Application for removal or variation of a condition following grant of
planning permission. Town and Country Planning Act 1990.
Planning (Listed Buildings and Conservation Areas) Act 1990

Reserved matters application for the erection of 8no. dwellings (pursuant to planning permission 18/0708/OUT)

19/0726/RESM

Dwg No.
182071-P9002A

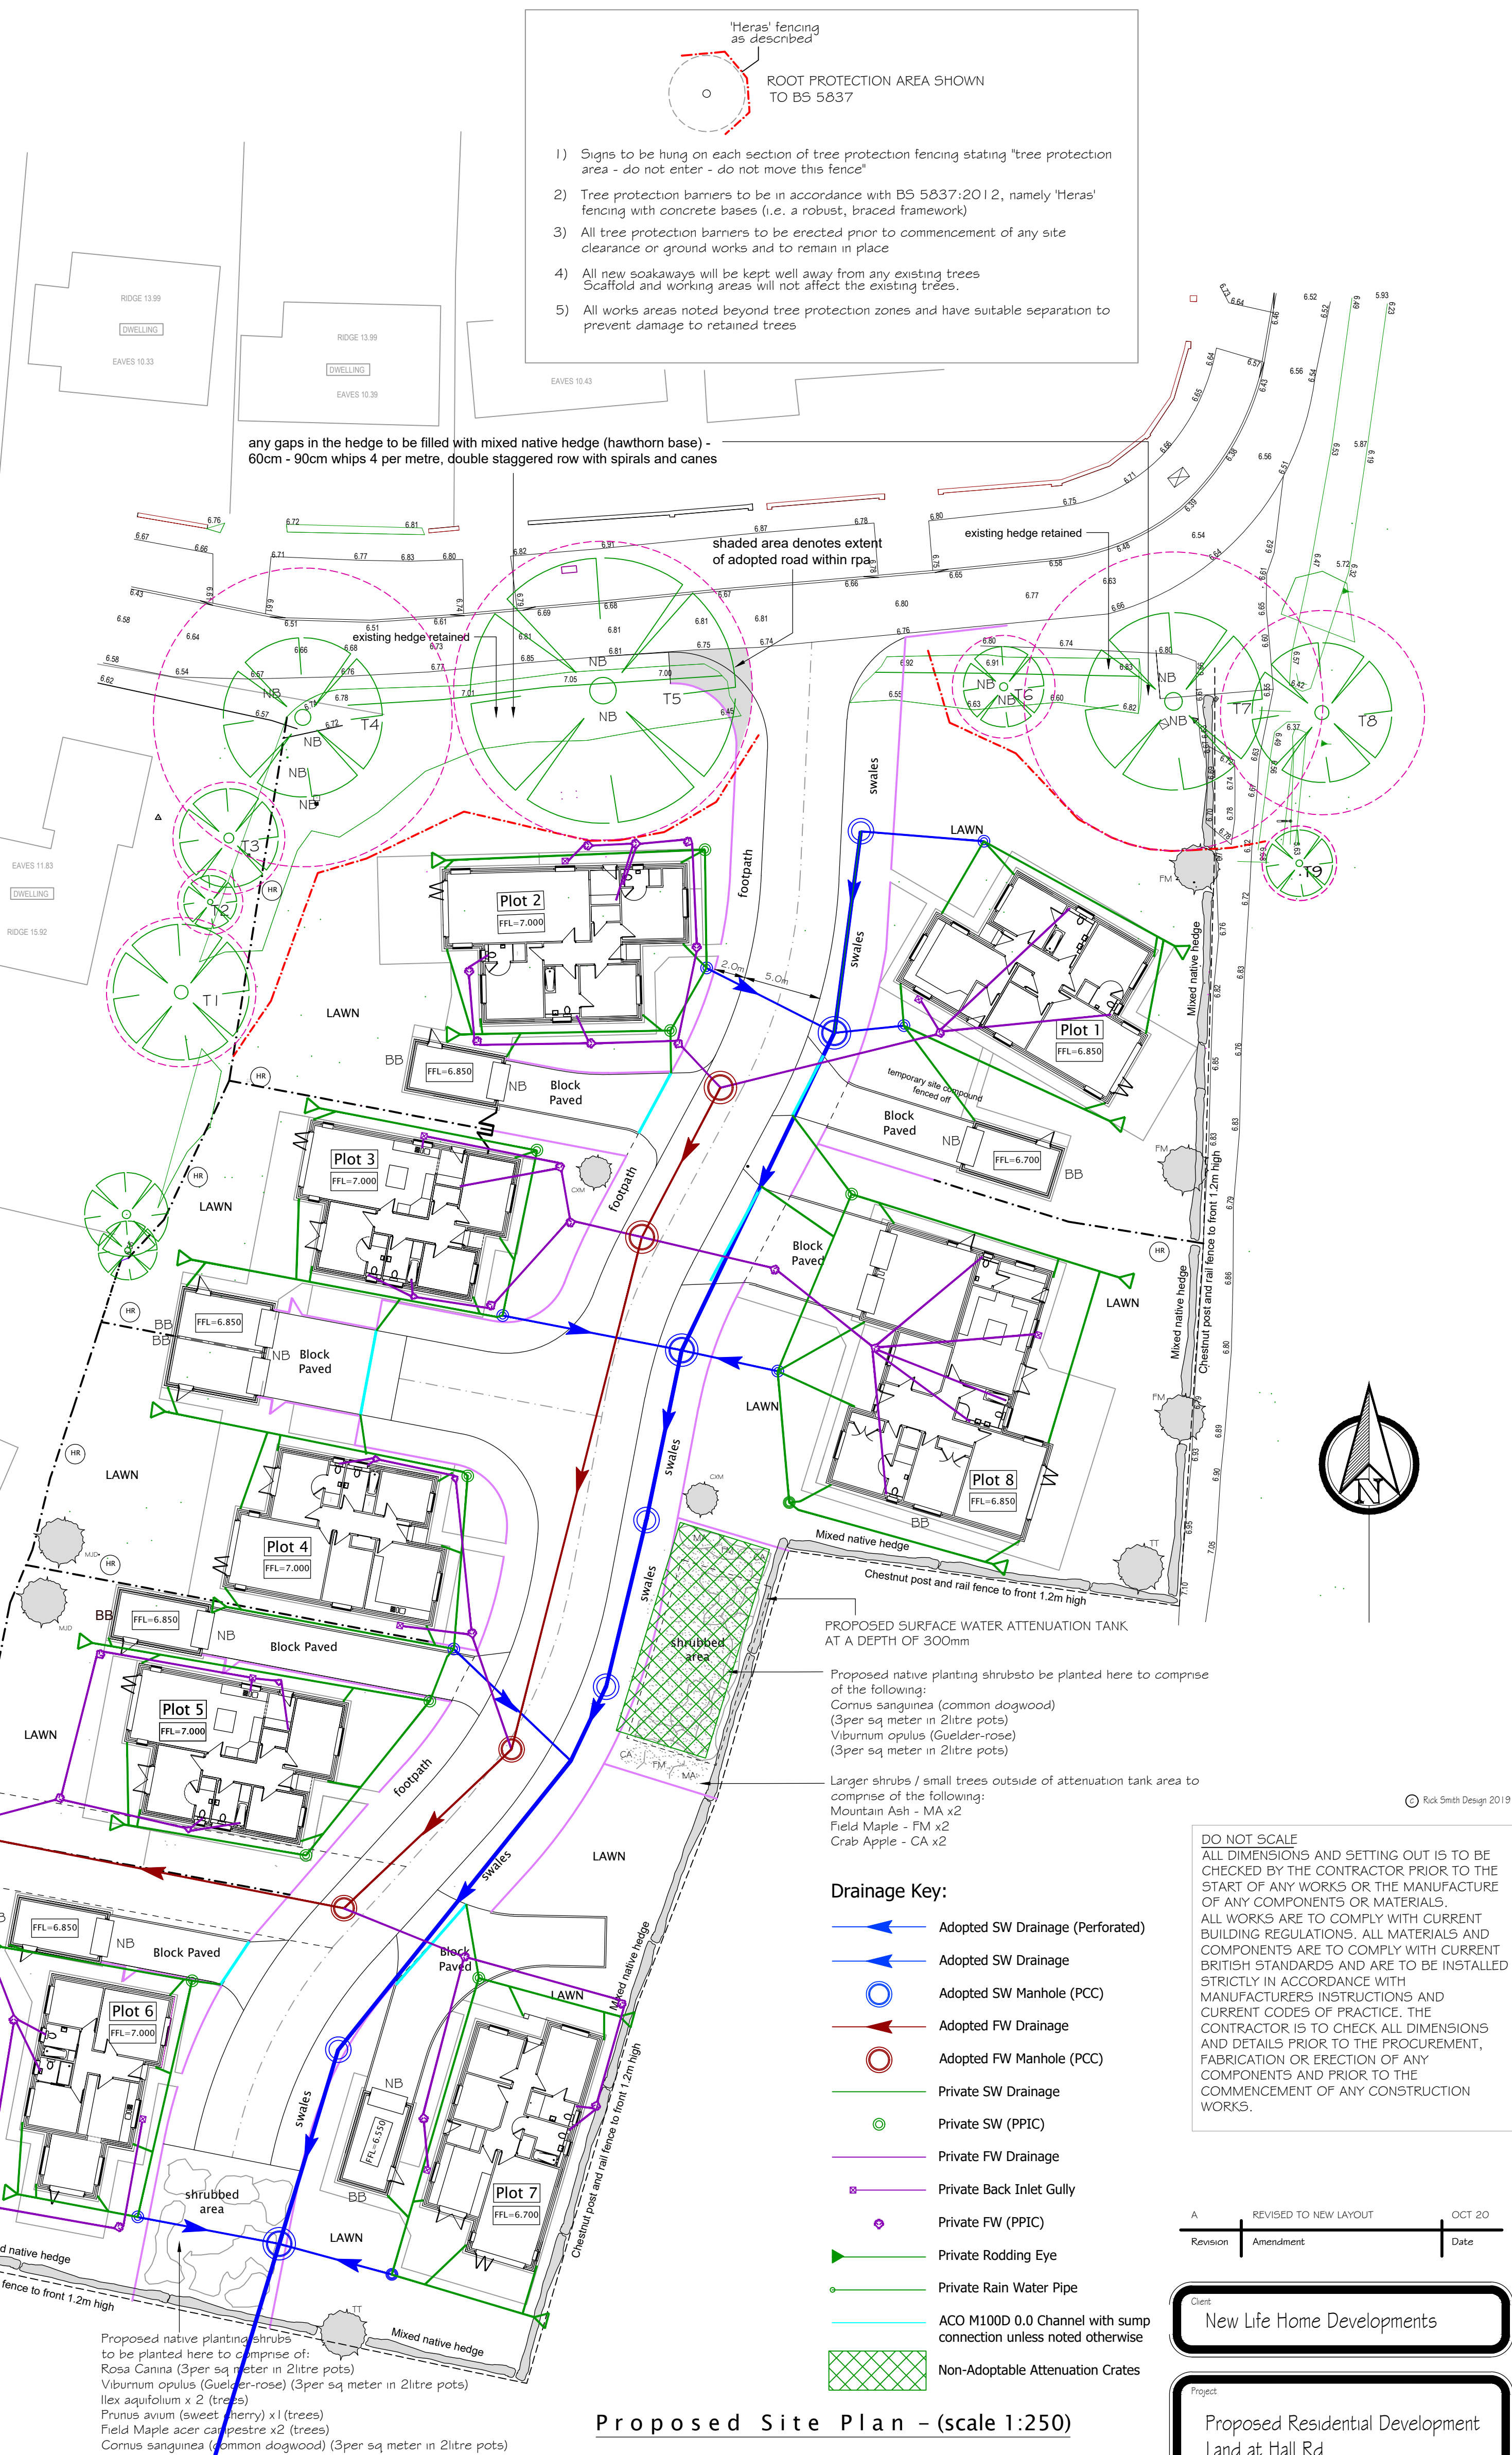
Condition 6 - With the removal of a double garage and replacing it with 2 single garages, the nesting boxes and bat boxes will be placed on each single garage rather than just the double garage.

Condition 7 - With the removal of the pumping station, we have created an easement to go through a neighbouring property. In order to create the 6m wide easement, we had to replace the double garage shared by plots 5 and 6, with a single garage for plot 6 only and the addition of a single garage to plot 5. Plot 6 also had to move south slightly to accommodate the easement. Superseded drawings are now numbers 182071-P9002A (site plan), 180419-WDK-00-SI-DR-C-33000-P06-Section 104 Adoptable Drainage Plan, 180419-WDK-00-SI-DR-D-33200-P03-Adoptable Drainage Manhole Schedule and 180419-WDK-00-SI-DR-D-33300-P03-Adoptable Drainage Longsections.

Condition 6 - With the removal of a double garage and replacing it with 2 single garages, the nesting boxes and bat boxes will be placed on each single garage

rather than just the double garage. Superseded drawing is now number 182071-P9002A
